WEST SUSSEX COUNTY COUNCIL CONSULTATION

TO:	Arun District Council FAO: Michael Eastham
FROM:	Highways, WSCC
DATE:	17/01/2019
LOCATION:	Land East of, Orchard Gardens, Woodgate, Chichester
SUBJECT:	AL/129/18/OUT Outline application with some matters reserved for the development of 55 No. units with public open space & affordable housing (resubmission following AL/111/16/OUT).
DATE OF SITE VISIT:	Previously in 2016 as part of AL/111/16
RECOMMENDATION:	☐ Advice ☐ Objection ☐ Modification ☒ No Objection ☐ More Information ☐ Refusal
INFRASTRUCTURE DELIVERY PLAN CONTRIBUTION TOTAL:	£392,150

Access and Right Turn Lane (RTL)

Drawing 5919/100 showing Right Turn Lane

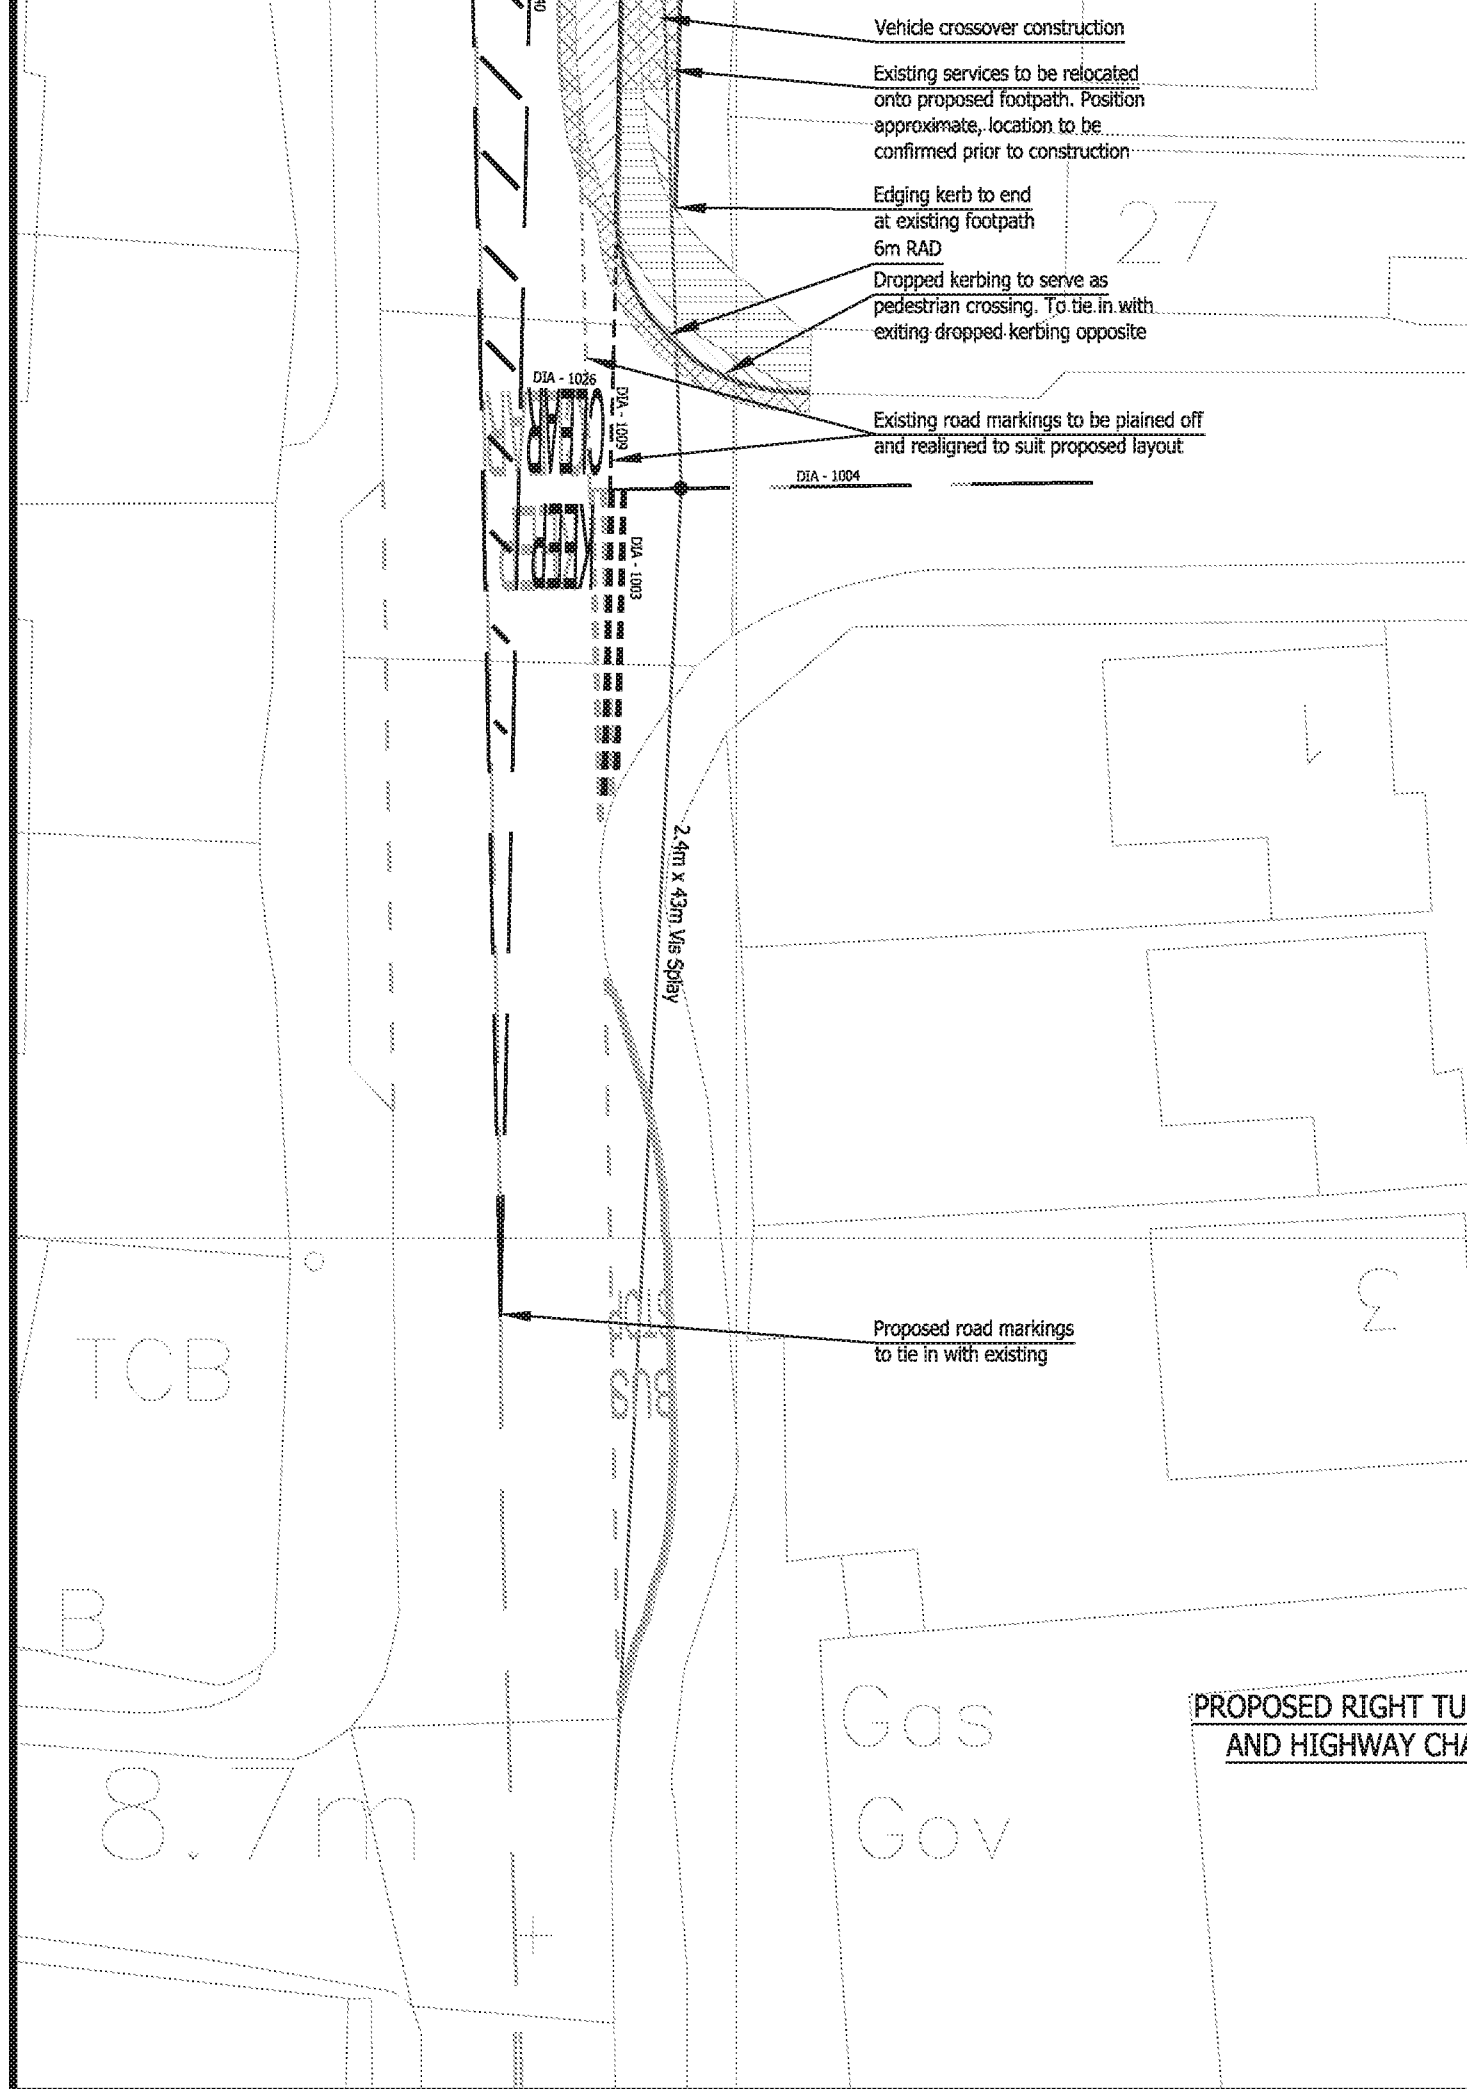
The LHA has held discussions with the applicants Transport Consultant on the areas forming part of the objections to the application consultation from November 2016, namely the integration with the Hook Lane RTL and the technical details of the proposed RTL. Following this the LHA are now satisfied with the proposed RTL based on the changes that have been made in accordance with drawing number 5919/100 Rev D, this includes:

- **Pedestrian Links**-Where the pedestrian crossing is located, the drawing has been modified to demonstrate the access points of the adjacent properties on the road to the east to ensure that there is no conflict.

- **Swept Path Diagrams and RTL**-The RTL has been widened to circa 3.5 metres and the accompanying swept path has been modified to show that it does not overhang onto the A29.

- **Alignment of RTL** - The southbound carriageway taper has been adjusted to allow for a 1 in 20 tapers.
- **Bus Shelter**-The existing bus shelter has been positioned accordingly to ensure it does not infringe on visibility immediately to the south. The shelter is of a cantilever design and we are satisfied with a cantilever wooden shelter. It is advised that the applicant liaises with the applicant for the Hook lane RTL on its re-location.

- **Visibility Splays at Junction with Orchard Gardens**-We have assessed the proposals against TD42/95 'Geometric Design of Major/Minor Priority Junctions'. The 2.4 by 43 metre splay proposed at the junction of Orchard Gardens is a departure from standards. MfS states that full visibility is not required in low speed urban environments, this proposal is not considered to meet this criteria. In difficult circumstances, the 'x' distance may be taken as a relaxation from 9.0m to 4.5m for lightly trafficked simple junctions, and in exceptionally difficult circumstances, to 2.4m back from the nearer edge of the major road running carriageway. In this instance we would be satisfied with a 3.0 metre 'X' distance by 43 metre visibility splay as a compromise. This has been agreed, but not demonstrated on this particular plan. We would request that the plan is modified to show the previously agreed 3.0 by 43 metre 'X' distance. The land in question for the splay would appear to be within publicly maintainable highway.

Having considered the above and on the basis that the drawing is updated to include the 3.0 metre 'X' distance the LHA does not consider that the proposal would have 'severe' impact on the operation of the highway network, therefore is not contrary to the National Planning Policy Framework (para 32), and that there are no transport grounds to resist the proposal.

No part of the development shall be first occupied until visibility splays of 3.0 metres by 43 metres have been provided at the existing site junction onto Westergate Street in accordance with plans and details submitted to and approved in writing by the Local Planning Authority. Once provided the splays shall thereafter be maintained and kept free of all obstructions over a height of 0.6 metre above adjoining carriageway level or as otherwise agreed.
